EF13/4990: DOC16/176983

Re: Yass Valley Wind Farm Project – Mod 1

ATTACHMENT A**NSW EPA - Review and comments on Modification Application Noise Assessment****Proposed Modification 1 – Yass Valley (Coppabella) Wind Farm – SSD 6698****November 2017****1. Correction - low frequency metric**

Figure 7-1 Noise contour map showing associated and non-associated receivers

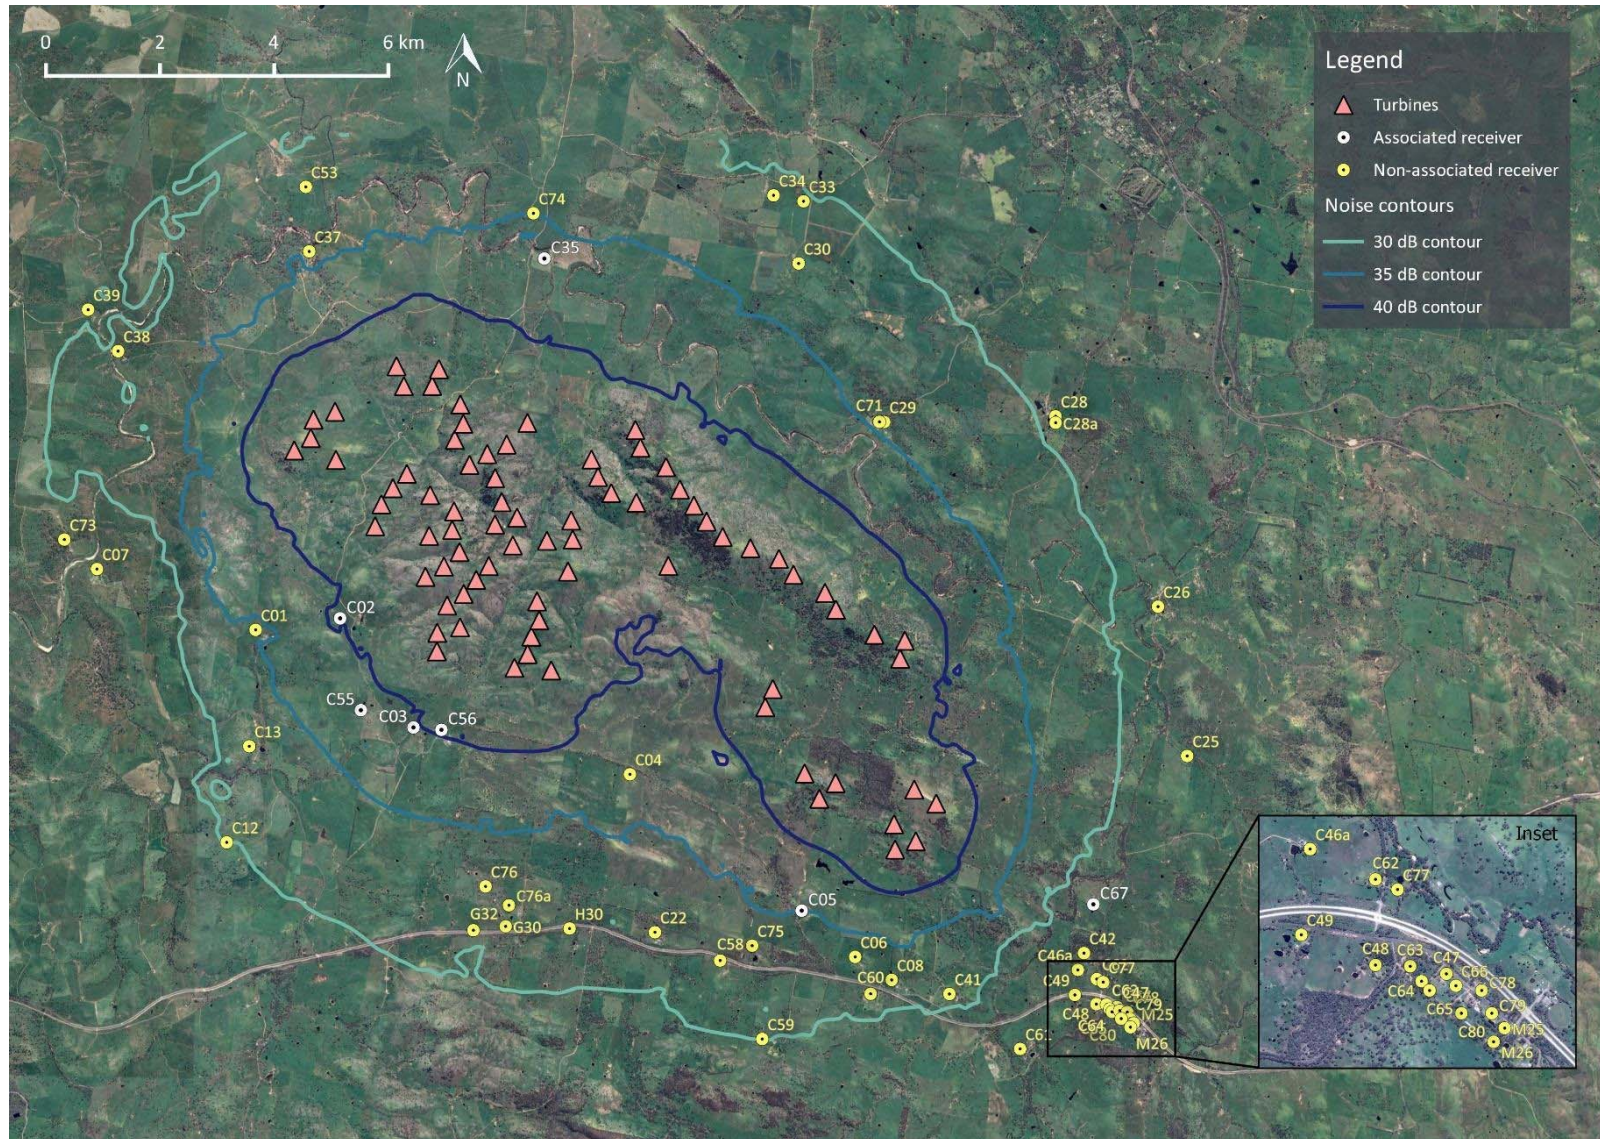
The EPA notes that sector management or operating some turbines in a sound management mode could be used to address the predicted 1.7 dB exceedance at one receiver and meet the adopted noise criteria. Sound management mode means specific turbines always operate in a low noise operation mode whereas sector management means specific turbines would only operate in a low noise mode under certain meteorological conditions.

The EPA suggests that DPE should confirm with the proponent whether the project would remain financially viable if sector management mode was used to enable compliance at one receiver where a predicted level of 36.7 dBA against the most conservative 35 dBA criterion is predicted. The Assessment recommends an updated background noise assessment and verification of sound power levels for the final installed turbines to refine these results and the magnitude of any exceedance.
